Appendix A – Response to Submissions Table

1.1 The Departments of Planning, Housing and Infrastructure

1.2 Penrith City Council

DRAWING TITLE
10.5m COUNCIL WASTE & B99 SWEEP TURNING PATHS
Site Simultaneous Entry / Exit (1)

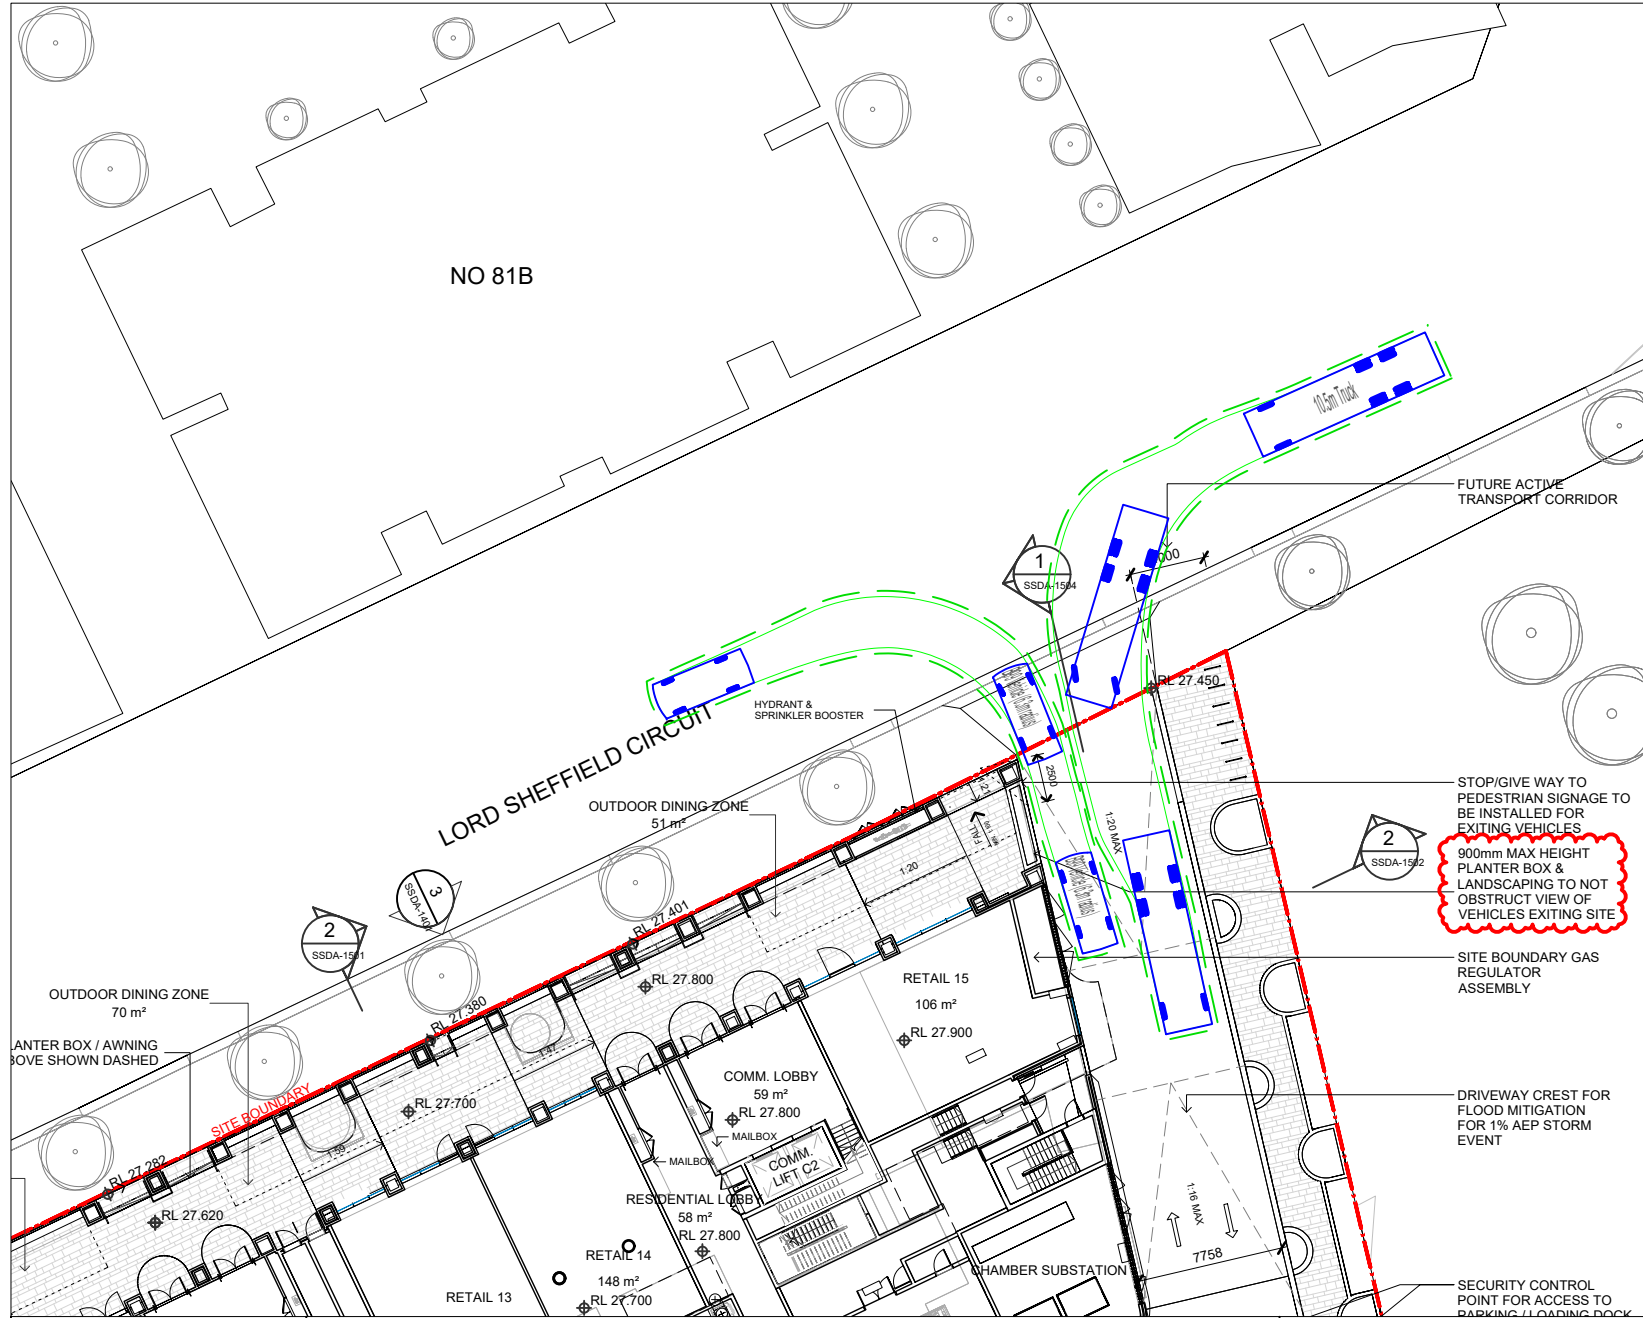
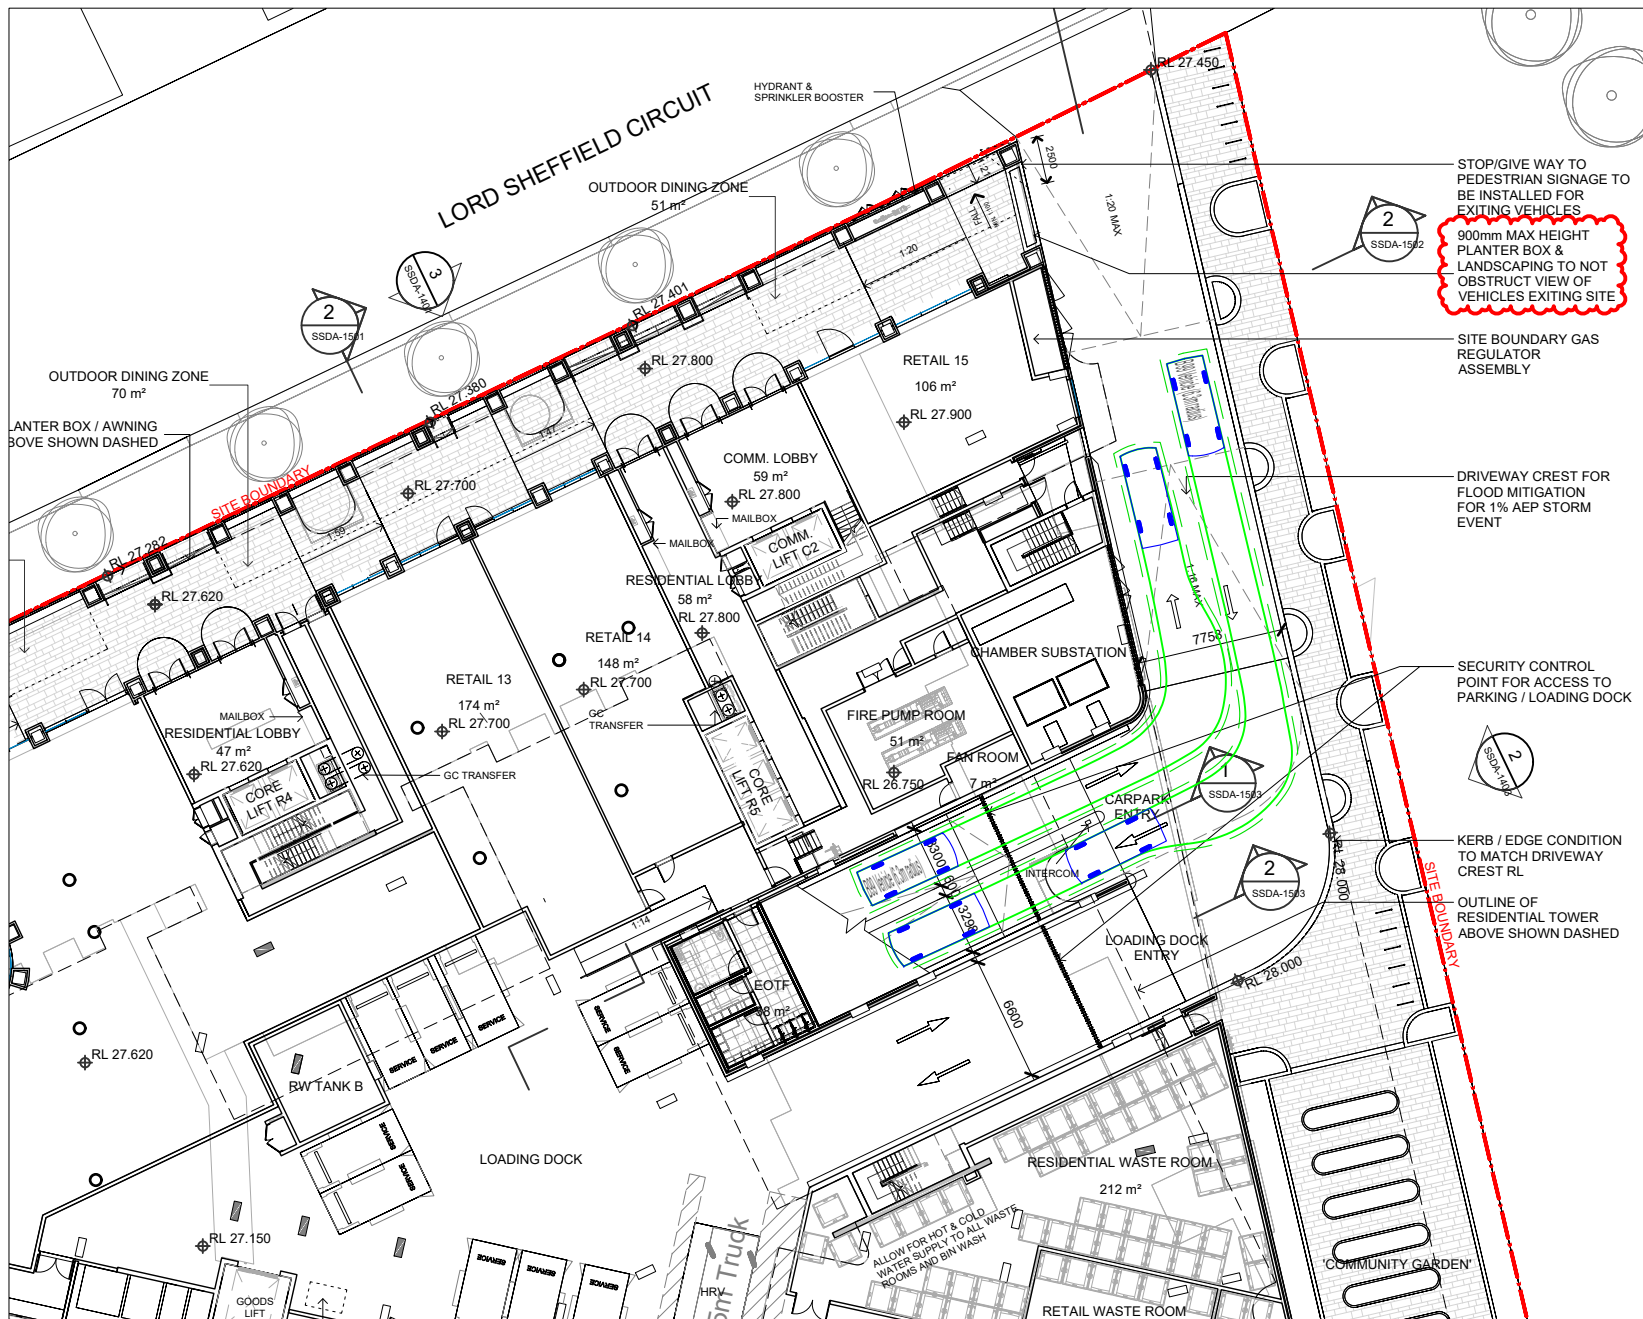
c) A swept path analysis shall be undertaken to demonstrate that vehicles will be capable of entering and exiting car spaces located adjacent to security control points via no more than three point turns when security access gates are closed.	Swept Paths have been prepared by Varga Traffic Planning (Appendix C) to confirm vehicles are capable of entering and existing car spaces.

SSDA-1003

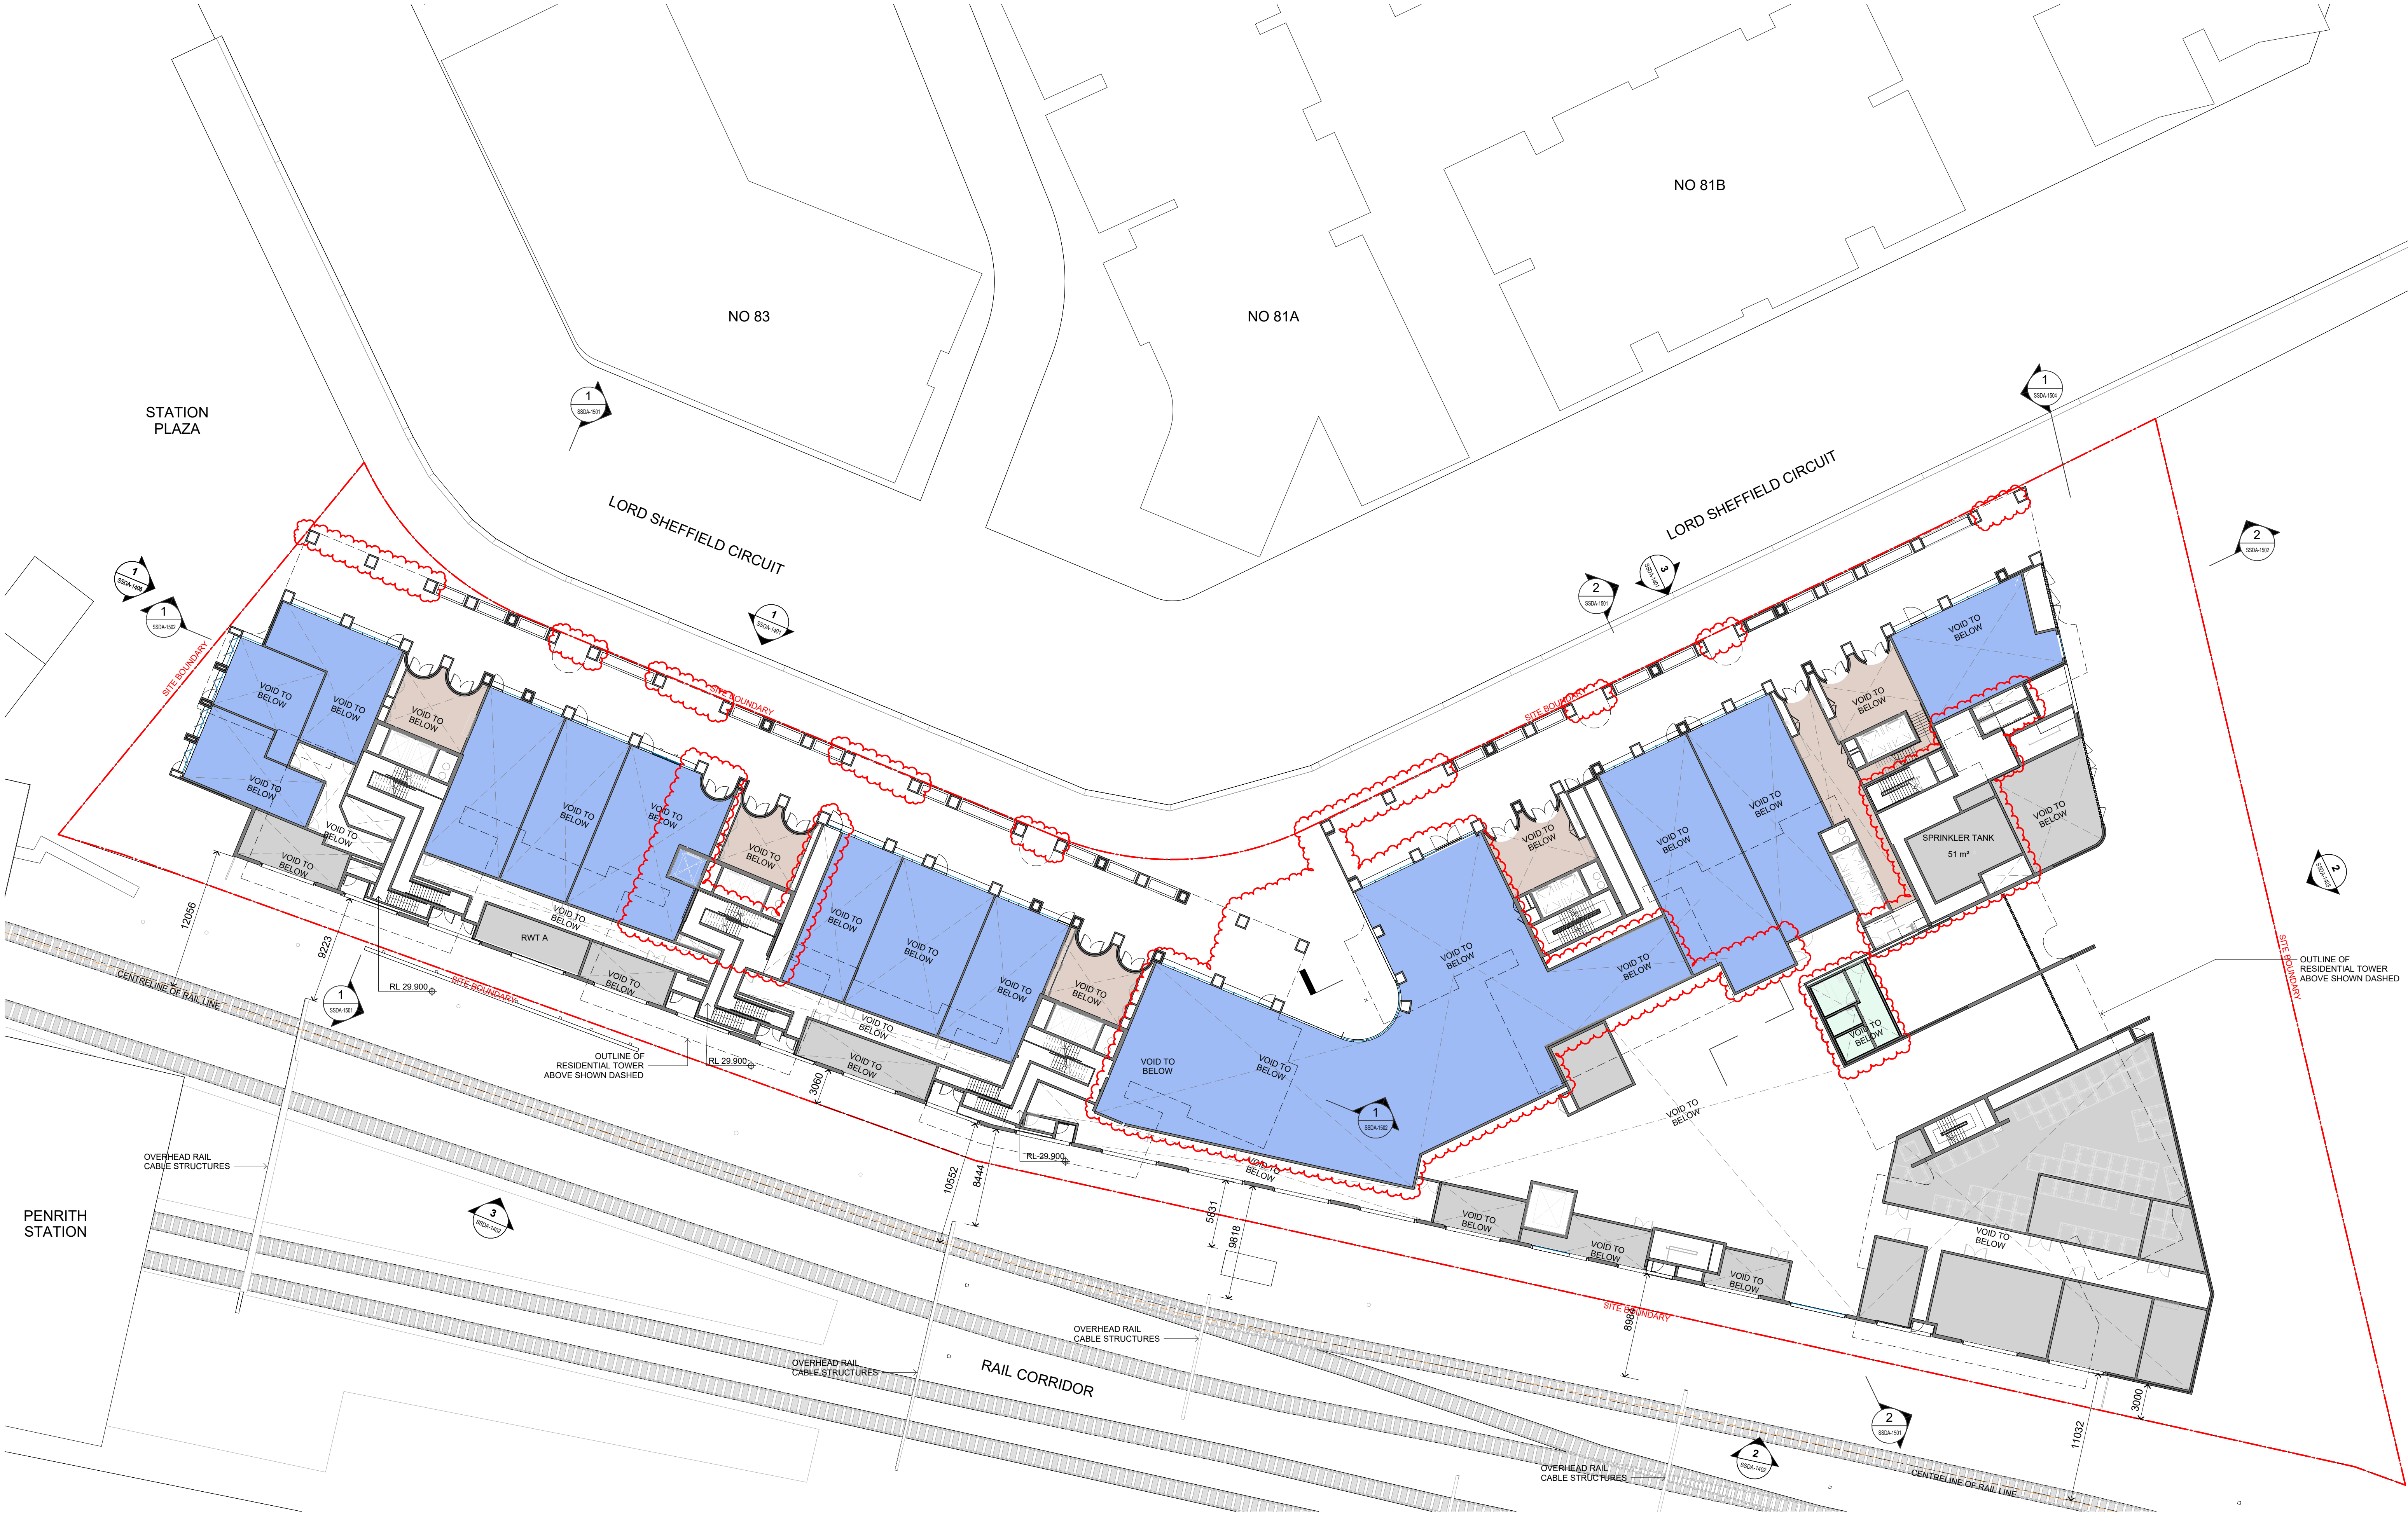
Issue	Response/Action
Access, Manoeuvring and Parking	
a) An additional ground floor planter box is proposed adjacent to the site access driveway. The height of the planter box must not obstruct driver sightlines as per AS 2890.1 and AS 2890.2.	As demonstrated on Amended Architectural Plan SSDA-1003 (Rev 27) (Appendix B), the planter box has been lowered to a maximum height of 900mm as to not obstruct driver sightlines.
